From: Laura Gibbons
Sent: 08 April 2019 09:25
To: Simon Davis; Planning.Responses
Subject: RE: BN/50/18/PL The Fallows

The proposed crate cross sections are now acceptable. However, the layout plans are still unacceptable for the following reasons:

Drawing 23B – SW Drainage Plan
Scale 1:200 @ A3

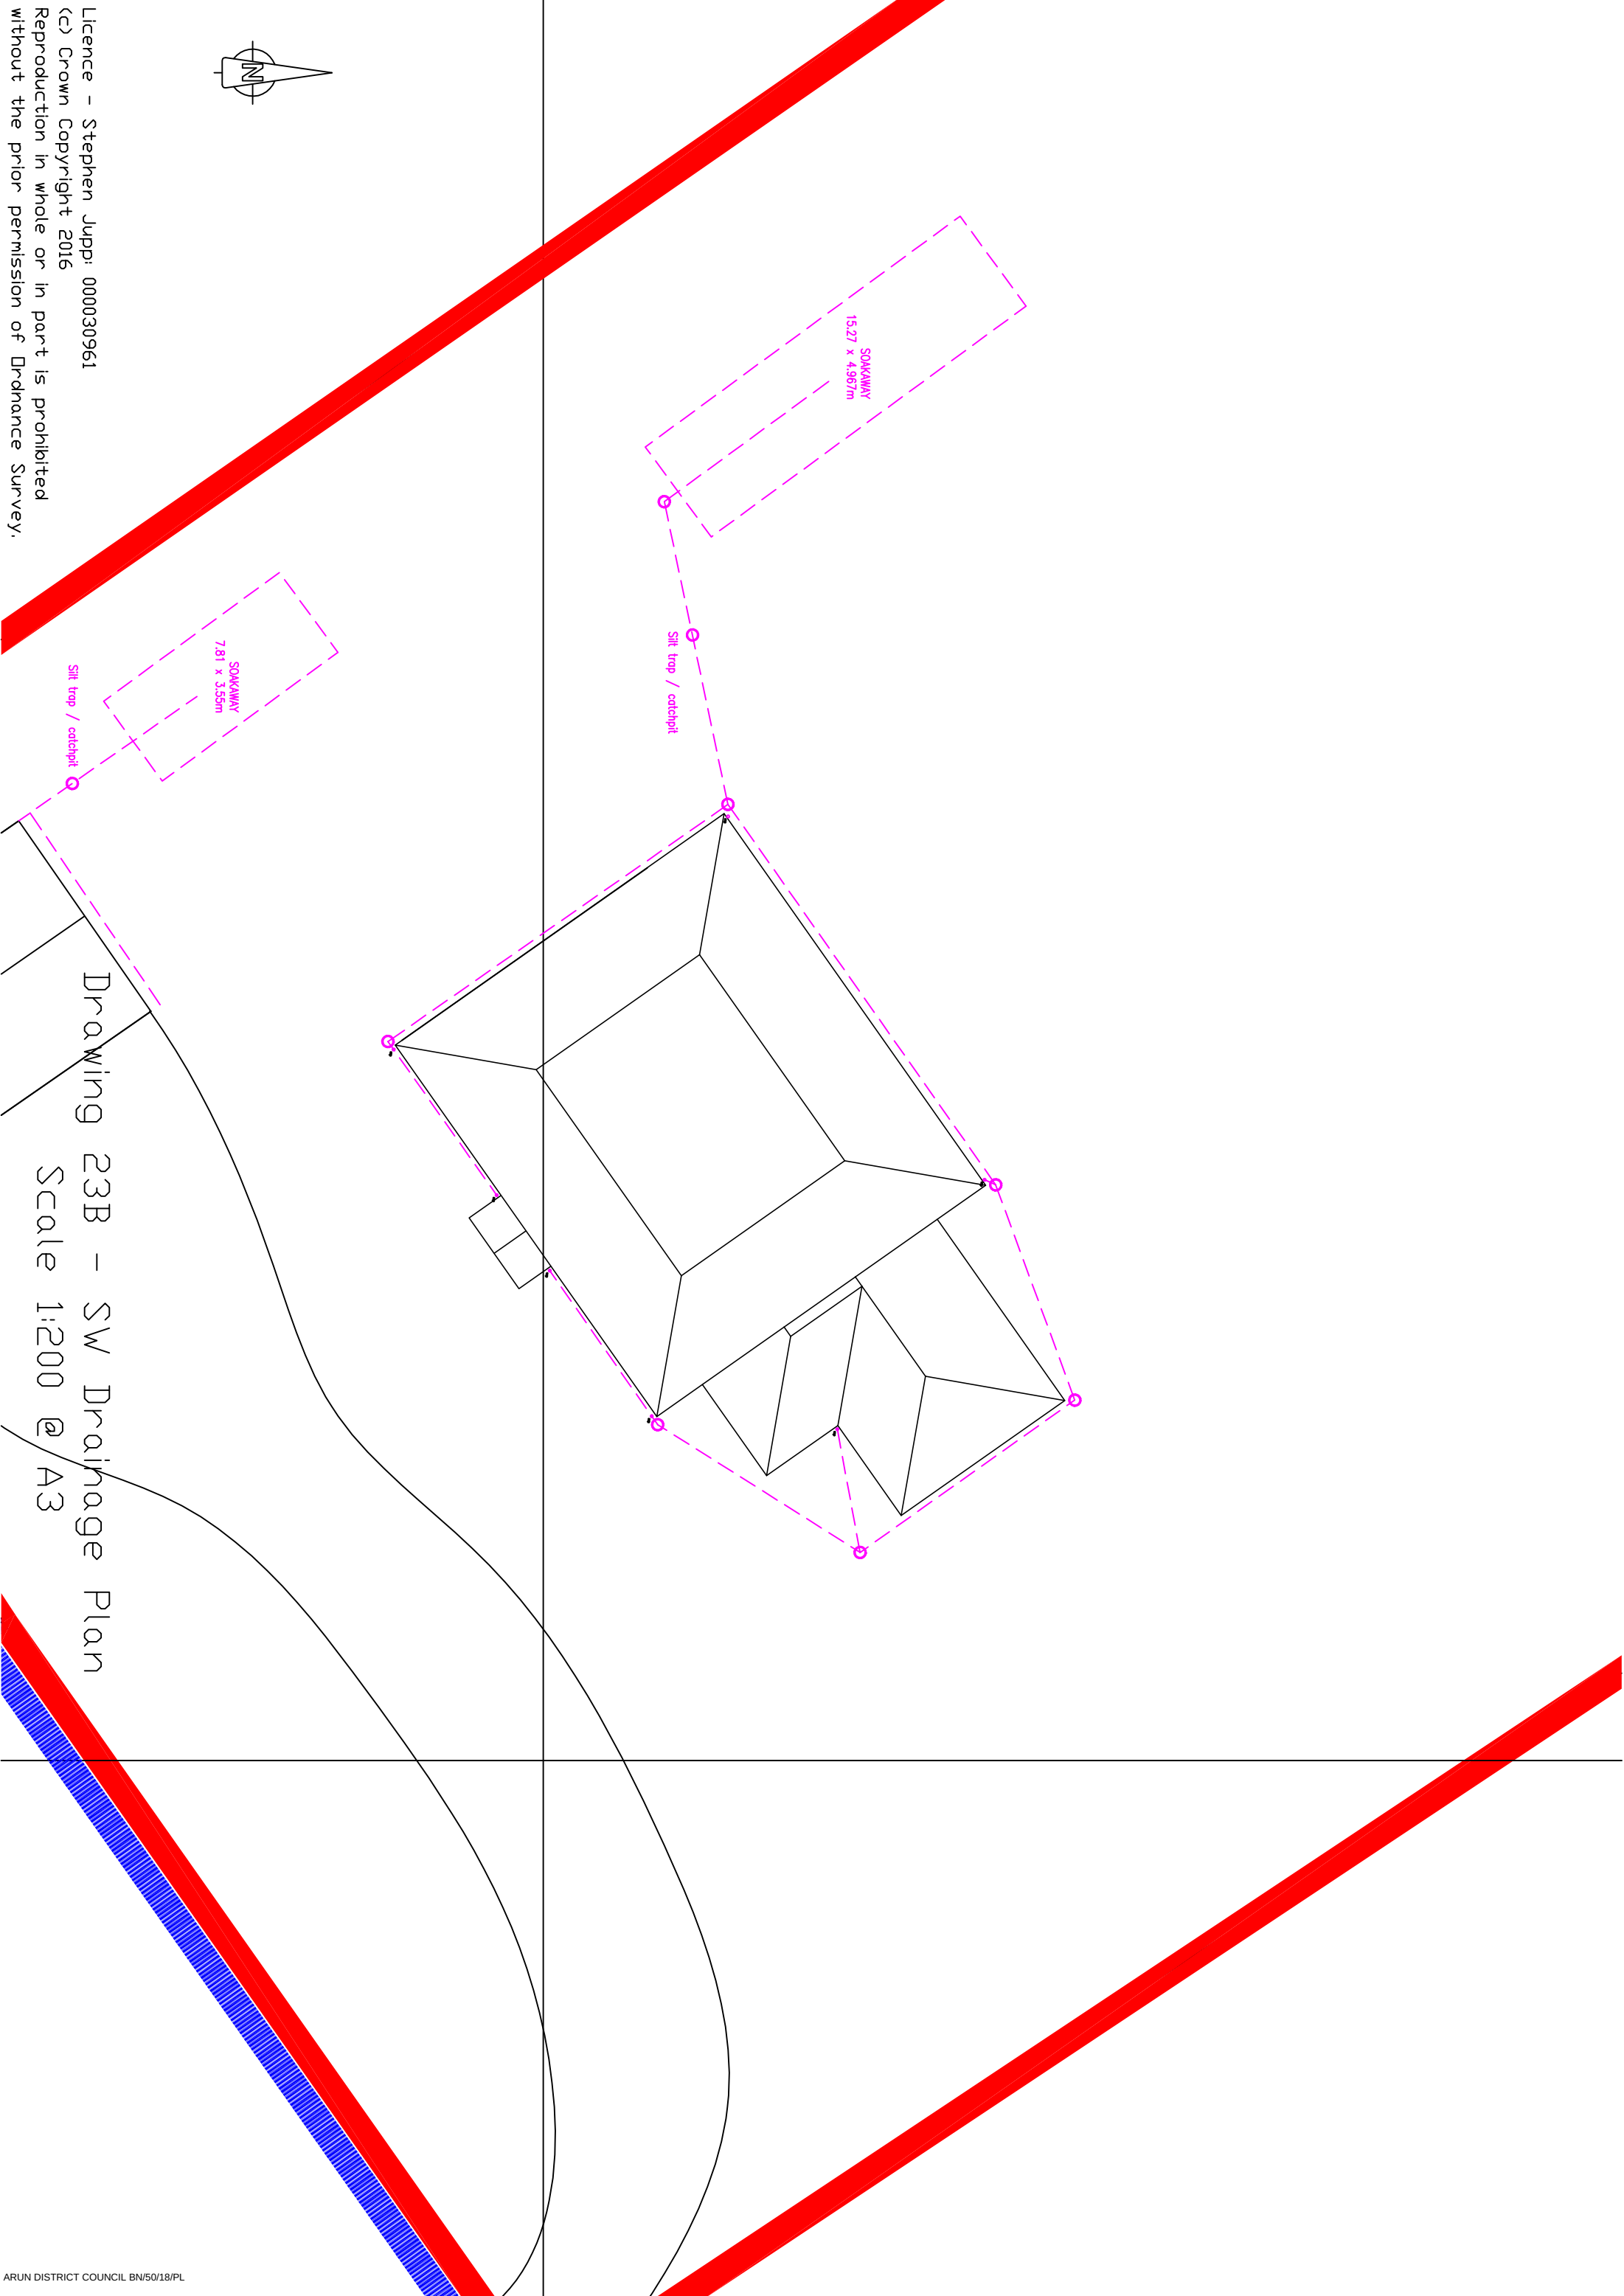
1. Two identical dimensioned crates are shown. Yet calculations provided state that a 15.27x4.967m soakaway is required for the house, and one 7.81x3.55m soakaway is required for the garage.
2. No invert or cover levels are provided.
3. No dimensions are provided for the soakaways.
4. Silt traps not provided.
5. Pipe diameters, falls, materials not included.

I note that calculations for two soakaways are provided, yet only one is shown on the layout plan. Please ensure that layout plans meet calculation requirements.

- All surface water drainage pipes labelled with; diameters, pipe materials, falls and invert levels.
- All infiltrating structures (including permeable paving) labelled with; dimensions, invert and cover levels.
- All manholes labelled with; cover levels, invert levels, cover types detailed.
- All silt traps clearly labelled with sump depths."

Furthermore, a location plan showing the soakaways and upstream pipe work including catchpits needs to be provided. This plan needs to include invert and cover levels.

Please can the plan be updated to cover these points.
